**Subject: Mayberry Filing No.5 - (PUDSP233)**

The Parks and Community Services Department has reviewed Mayberry Filing No.5 combined PUD / Preliminary Plan and is submitting the following preliminary comments on behalf of El Paso County Parks. This application will be presented to the Park Advisory Board on December 13, 2023 and its recommendation will be provided after the meeting.

# Development Application Permit Review

PLANNED UNIT DEVELOPMENT & PRELIMINARY PLAN
A PORTION OF MAYBERRY, COLORADO SPRINGS, FILING NO. 1A

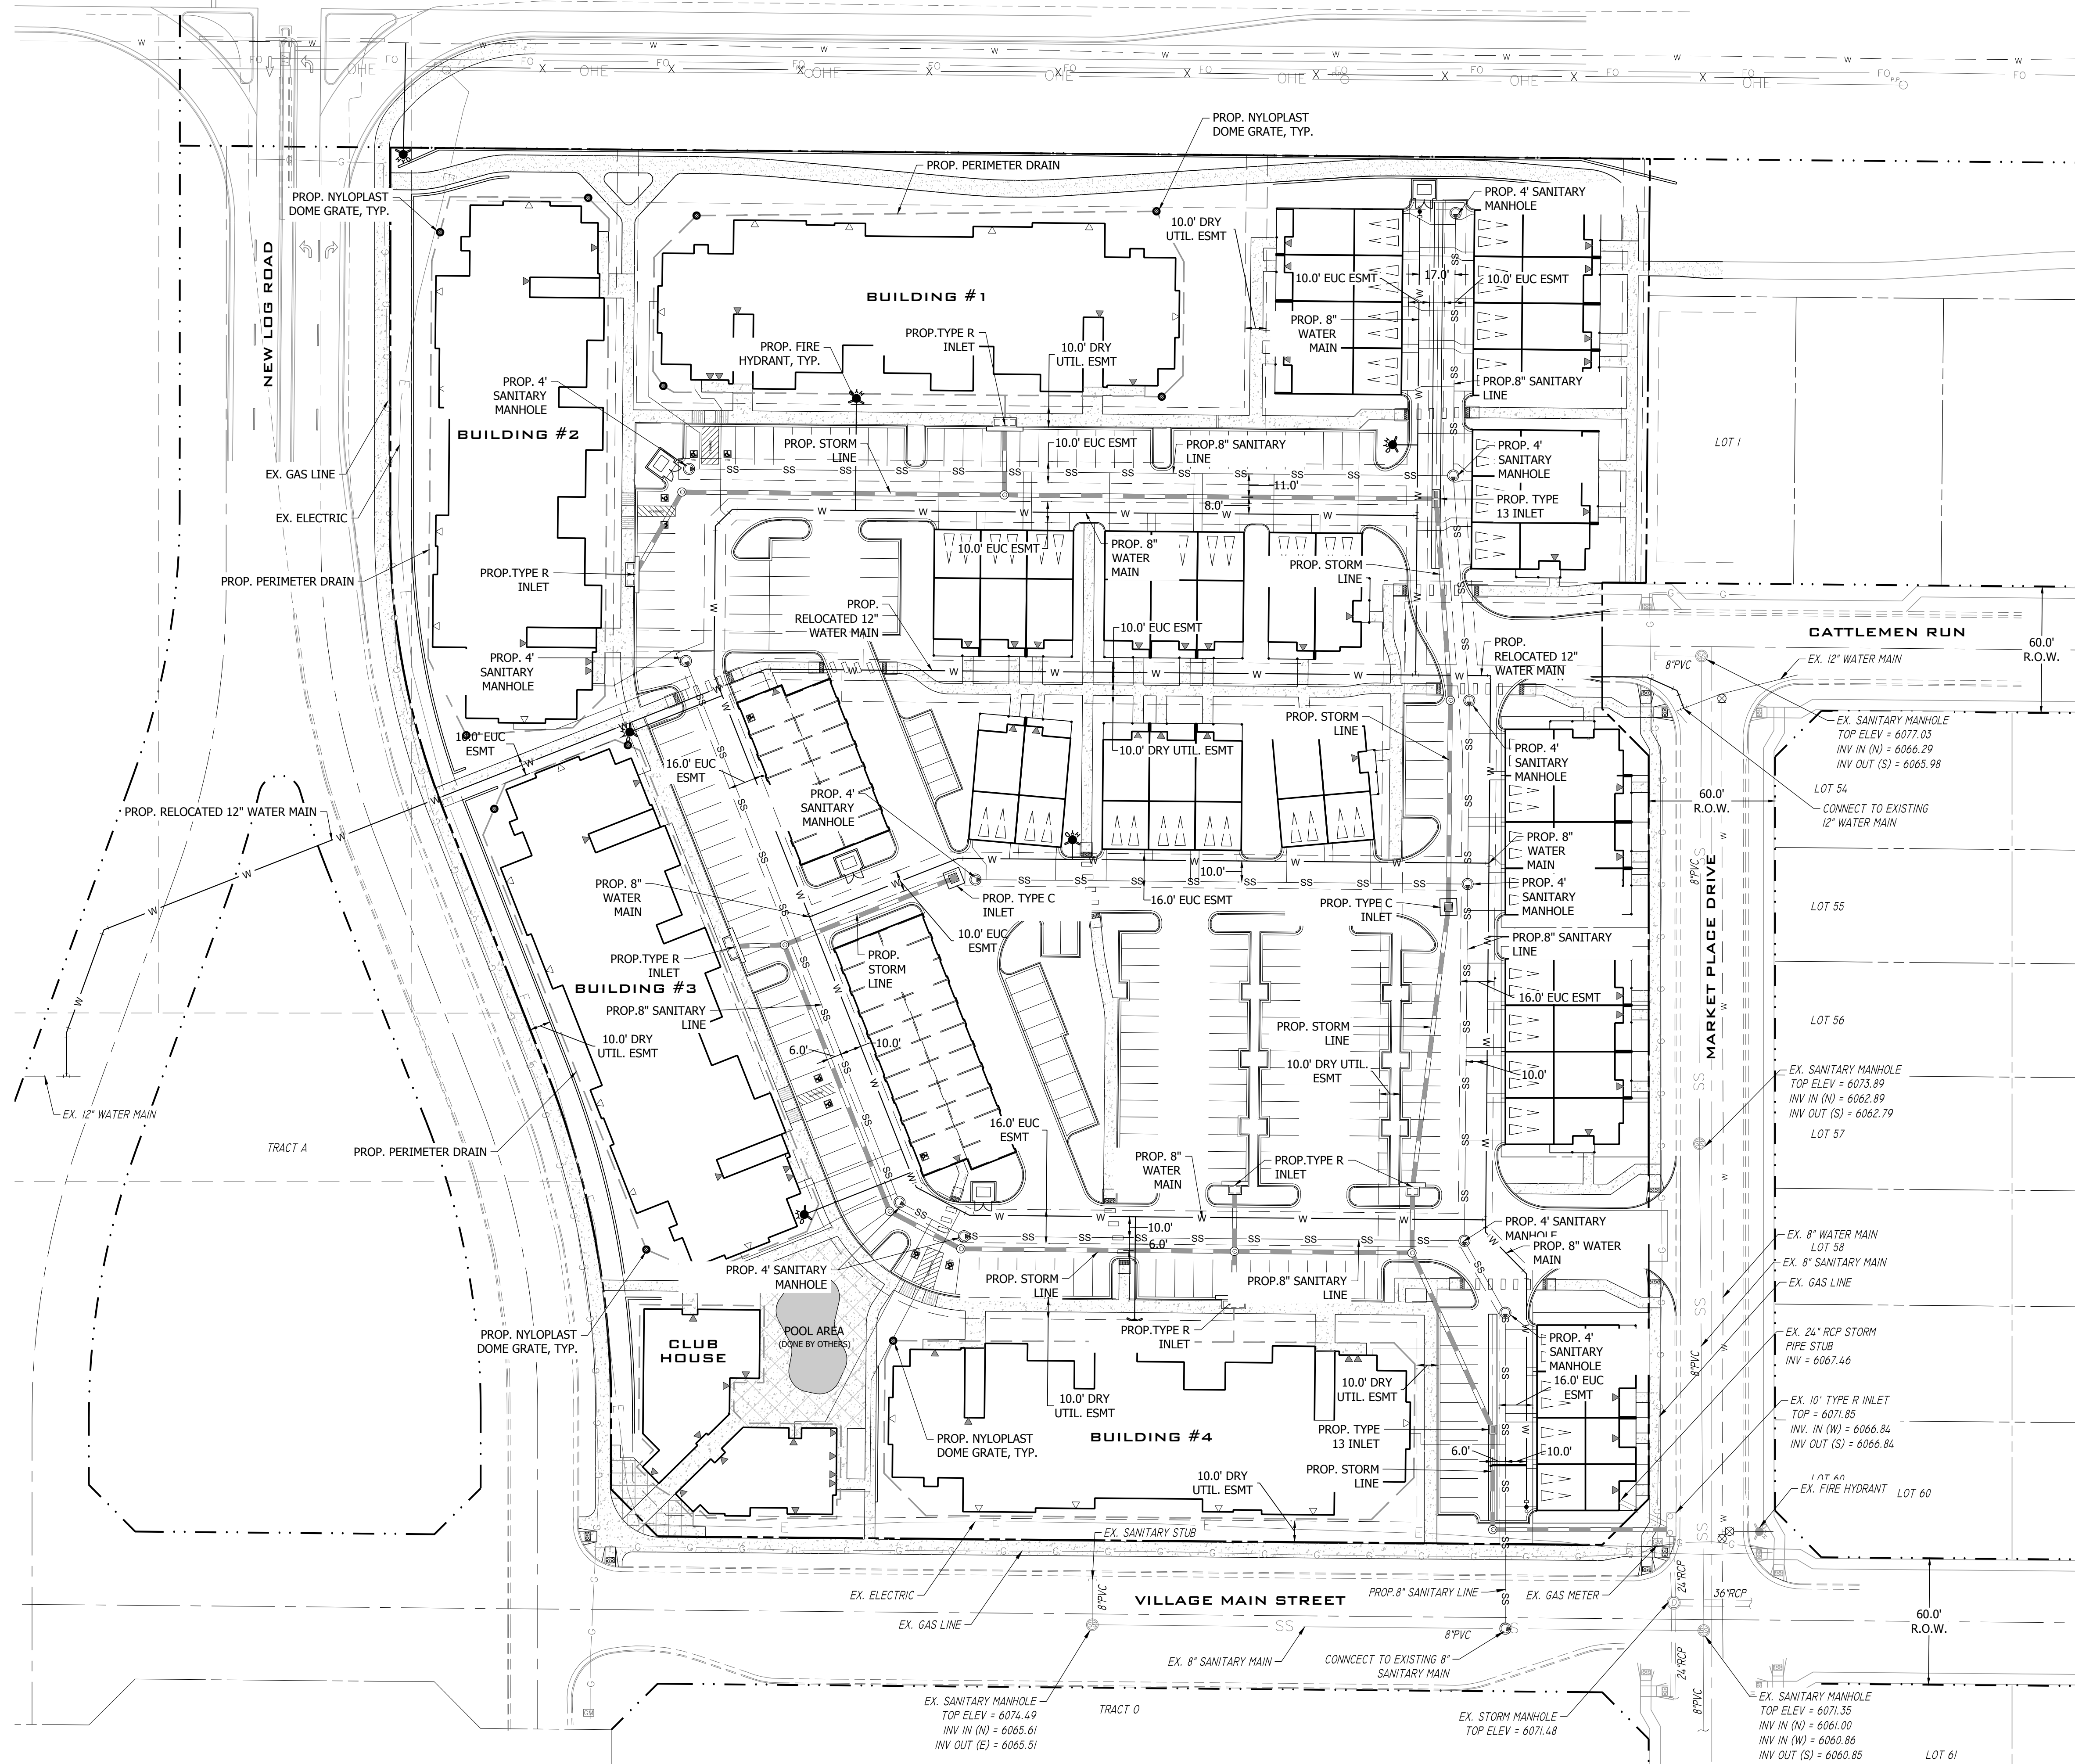
The El Paso County Parks Master Plan identifies two master-planned trails adjacent to the proposed facility. The proposed Highway 94 Bicycle Route runs east and west along Highway 94. This proposed trail will not be impacted by the project because it will be accommodated within the public right-of-way. The proposed Highway 94 Primary Regional Trail also runs east and west along Highway 94. This proposed trail would be impacted by the proposed facility because its alignment is on the south side of Highway 94. The Highway 94 Regional Trail alignment was previously dedicated to El Paso County on Mayberry Filing No.1 and does not appear to have been replatted since. The Highway 94 Regional Trail shall be labeled and shown on the current plan.

Mayberry Filing 5 shows an 8' sidewalk south of Highway 94 along the north property line of the site. The proposed 8' wide sidewalk would be an acceptable alignment for the Highway 94 Regional Trail, provided it has connections at the east and west end of the site to the future Highway 94 Regional Trail. According to the plan, the 8' wide sidewalk ends at the apartment buildings on the east end of the site and tees into an internal sidewalk. The 8' wide sidewalk shall be shown to connect to the future Highway 94 Regional Trail alignment to the east instead. At the west end of the project, the 8' wide sidewalk is shown ending at Mayberry Drive and teeing into a 7' wide internal north-south sidewalk. A tree is shown west of this intersection. Instead, the Highway 94 Regional Trail should be shown with a future connection to the west of Mayberry Drive with a crosswalk at the intersection.

County Parks requests trail easements where development projects impact proposed County trails. As it pertains to this application, the County requests that the landowner provide a 25-foot public trail easement along the south side of Highway 94

that allows for the construction and maintenance by El Paso County of the Highway 94 Primary Regional Trail, and this easement shall be shown and dedicated to El Paso County on the Final Plat.
